Our Ref: 689/013
Your Ref: 18/01333/F
Date: 11th October 2019

VARIATION OF CONDITIONS FOR PLANNING PERMISSION 18/01333/F

We write to submit information for the variation of conditions attached to planning permission 18/01333/F. The application was for the extension to existing Technical Site to provide new employment units comprising flexible B1(c) light industrial, B2 (general industrial), B8 (storage or distribution) uses with ancillary offices, storage, display and sales, together with associated access, parking and landscaping. The application to vary the conditions has been made via the planning portal under reference PP-08147840.

TITLE:  
**Building H Proposed Elevations**

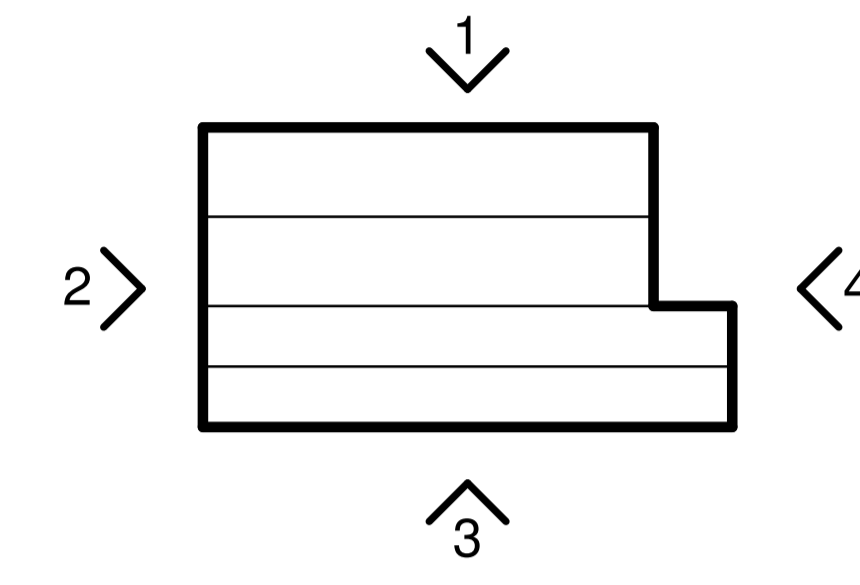
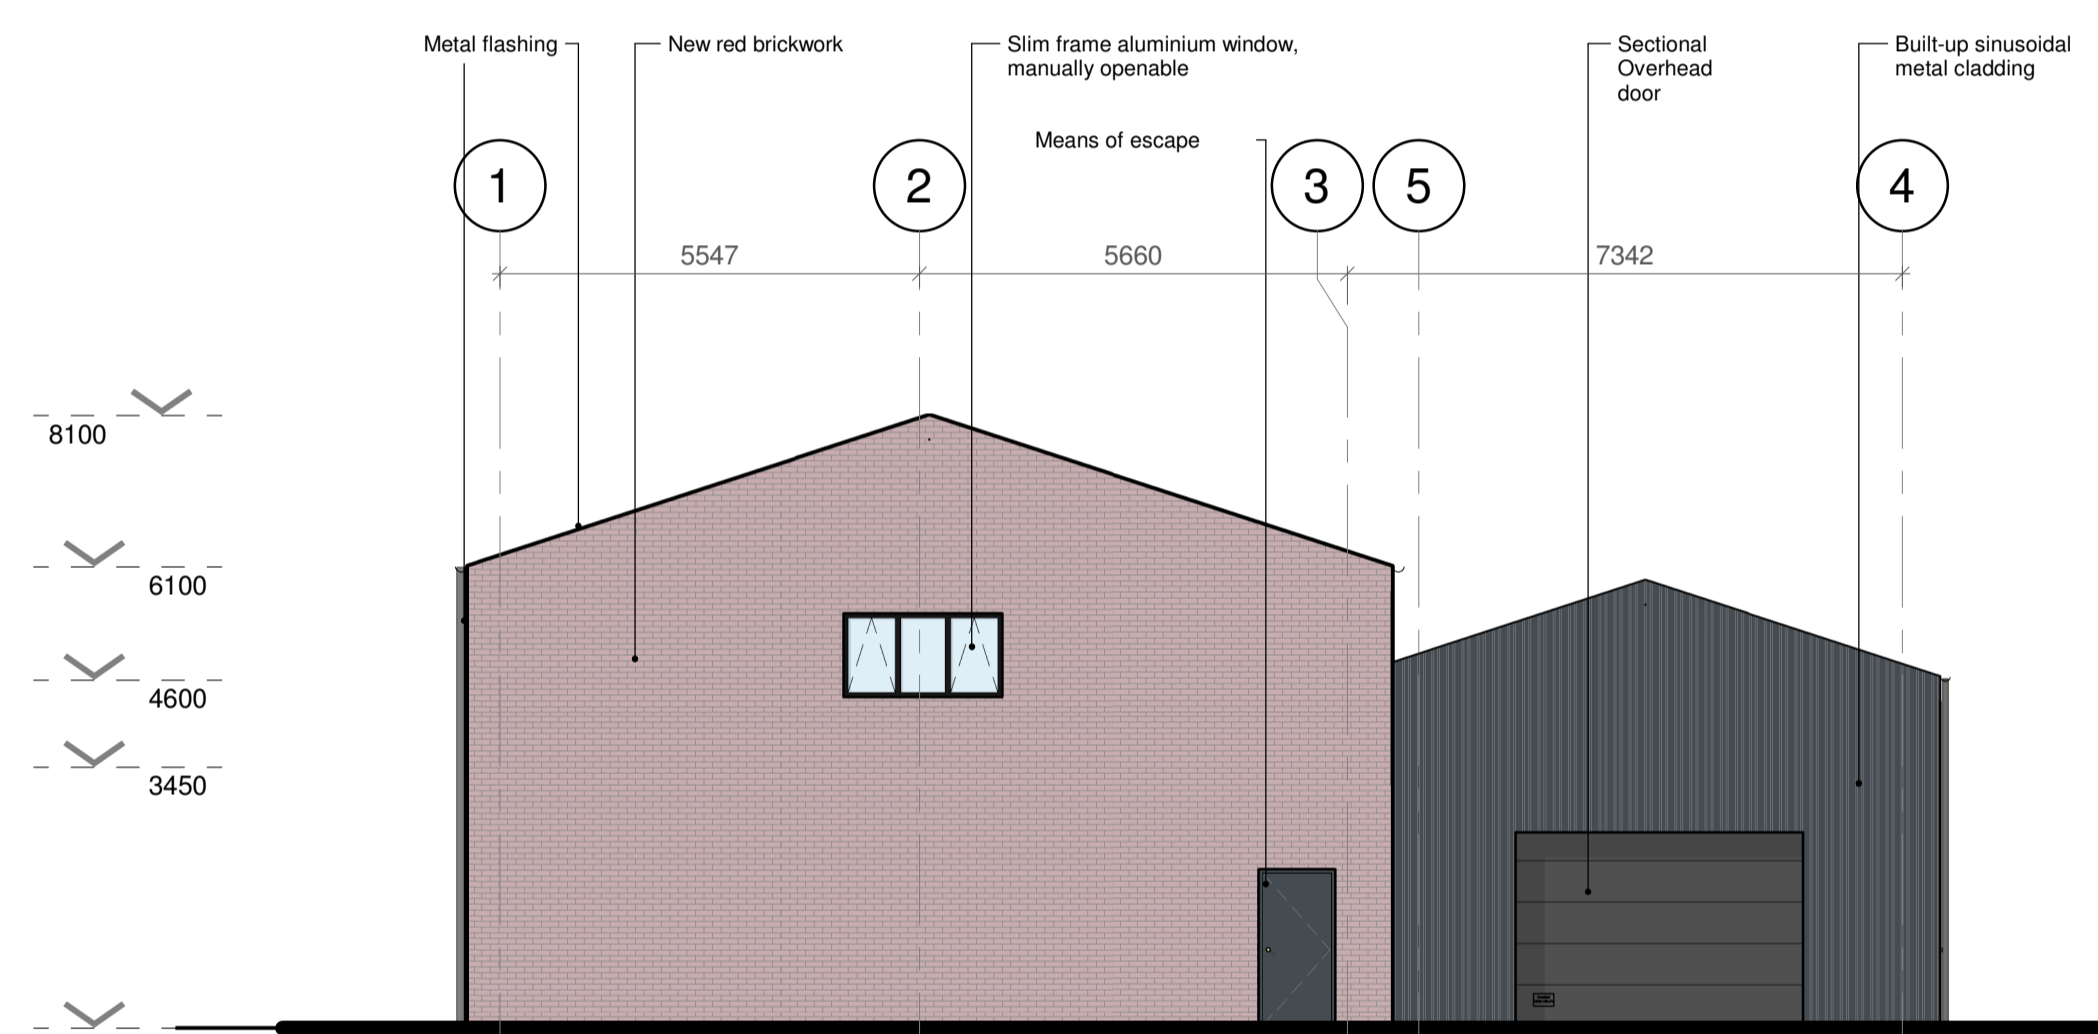
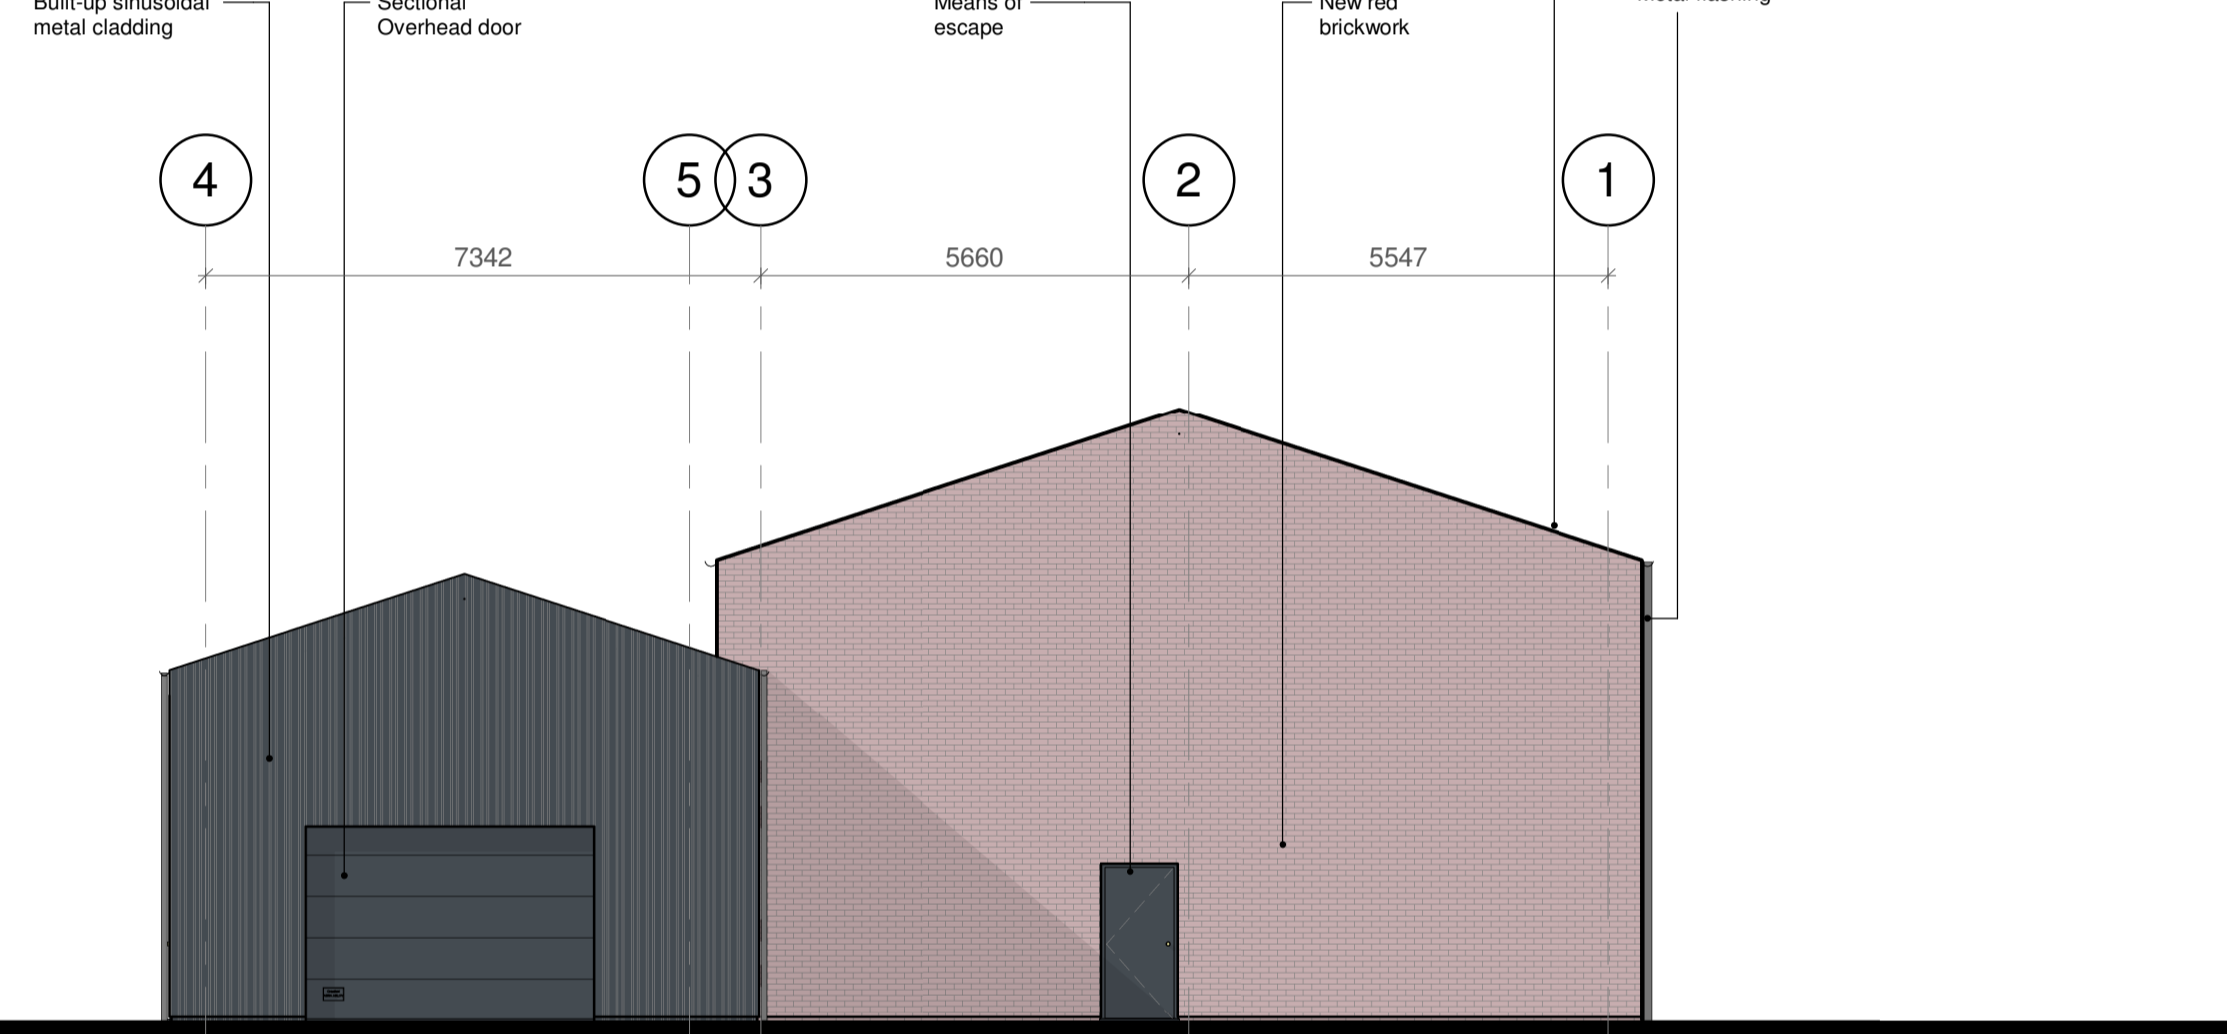
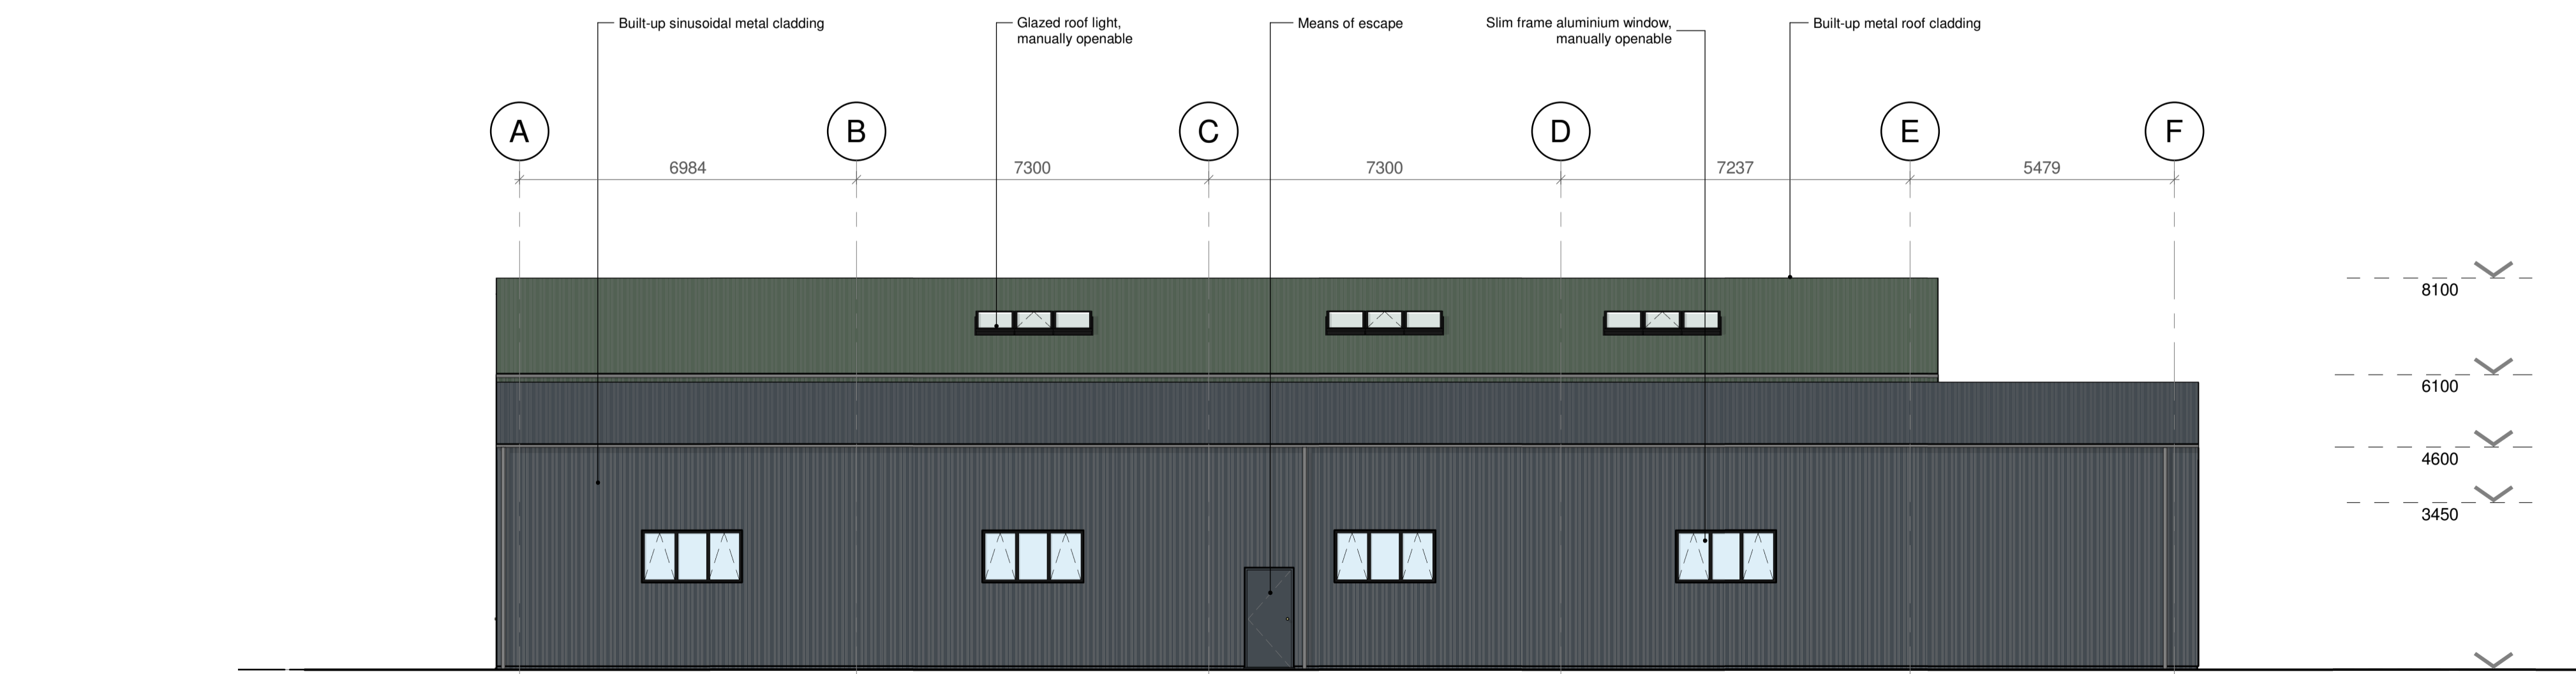
FF	Four windows size increased
	Roof	Two rooflights added
Unit F	GF	Escape door relocated
Unit H	GF	Four high level windows added
	Roof	Six rooflights relocated

TITLE:  
**Building D Proposed NE and SW Elevations**

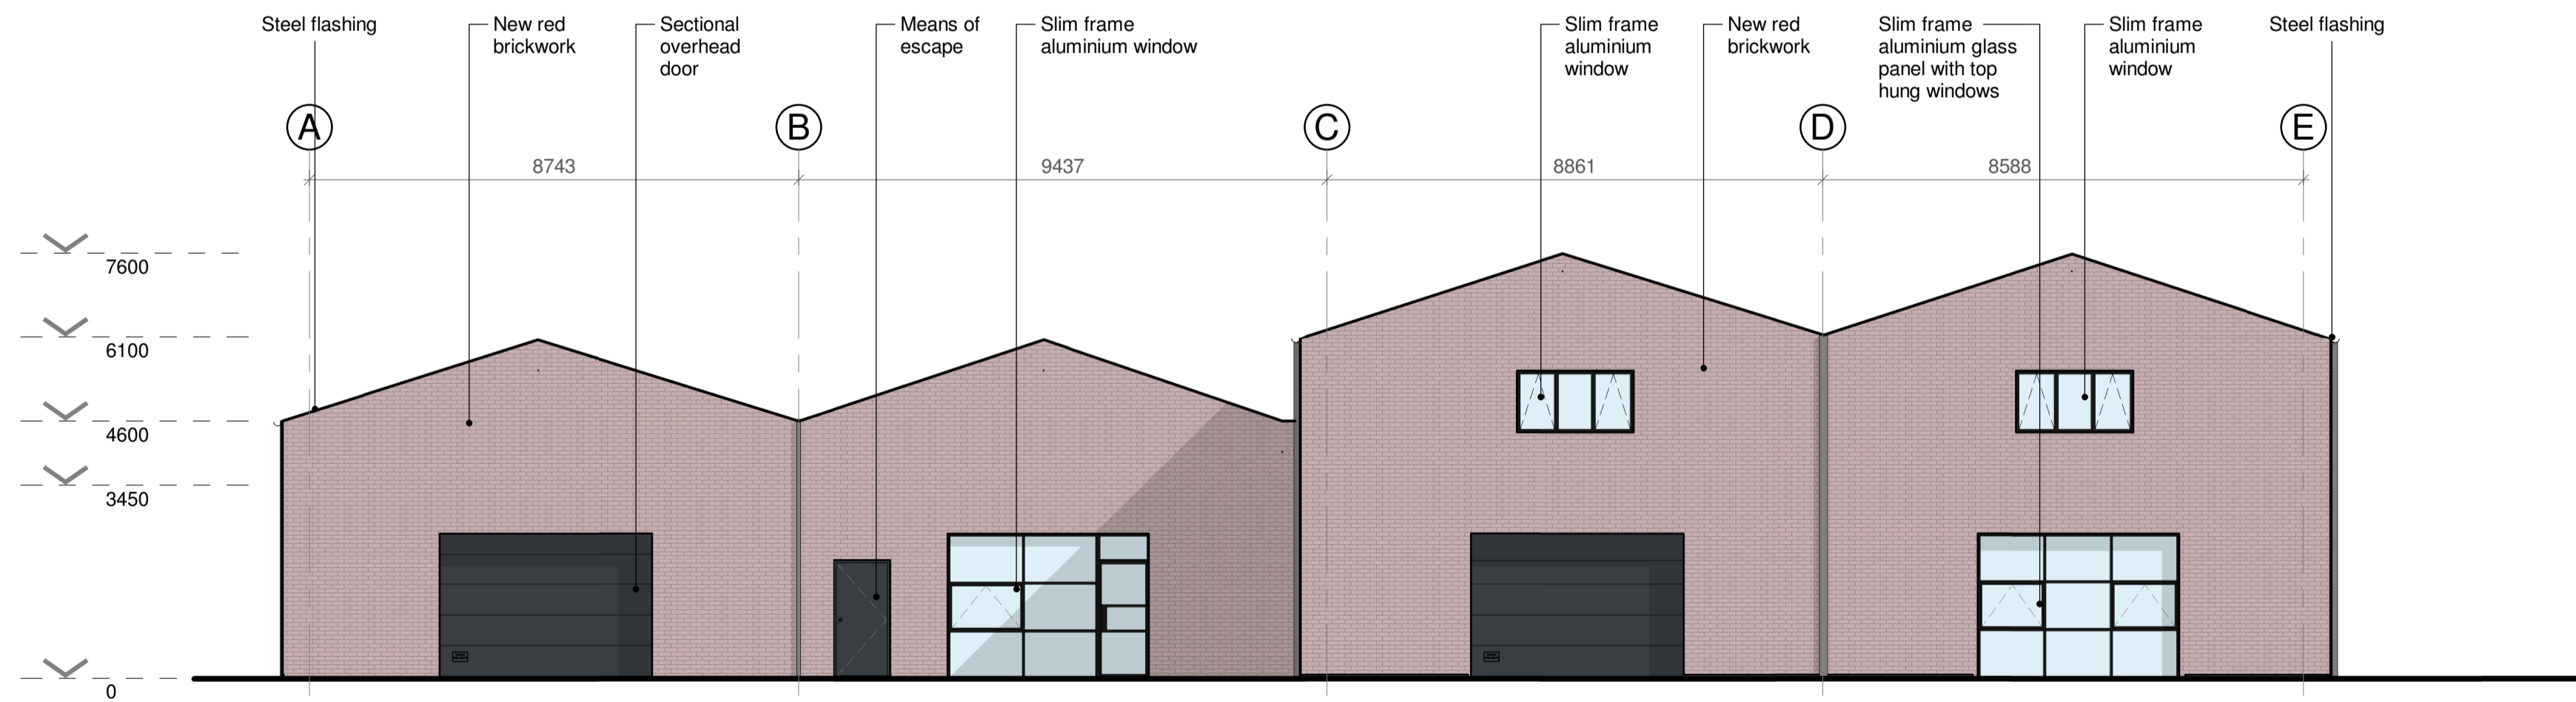
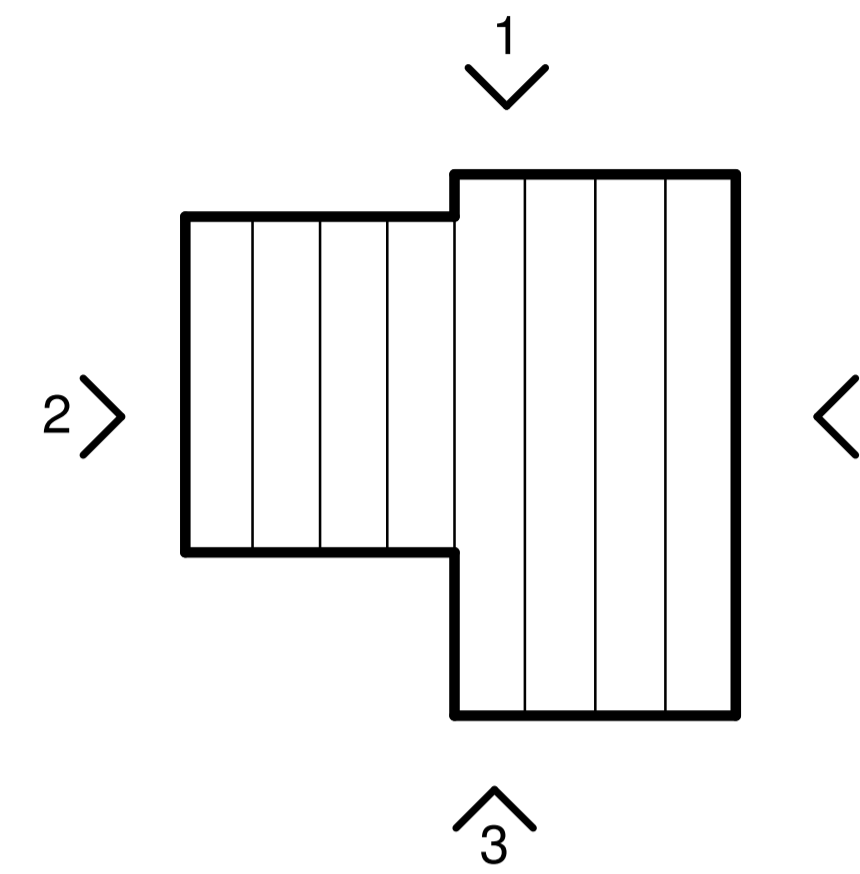
Perimeter handrail added
Unit D	GF	A glass panel with access door replaced with fully openable glass panel
		A glass panel replaced with fully openable glass panel
		Two sectional overhead doors replaced with two glass panels
		A glass panel added
		A glass panel relocated
		A glass panel with access door removed
		An escape door added
A sectional overhead door replaced with a glass panel with access door
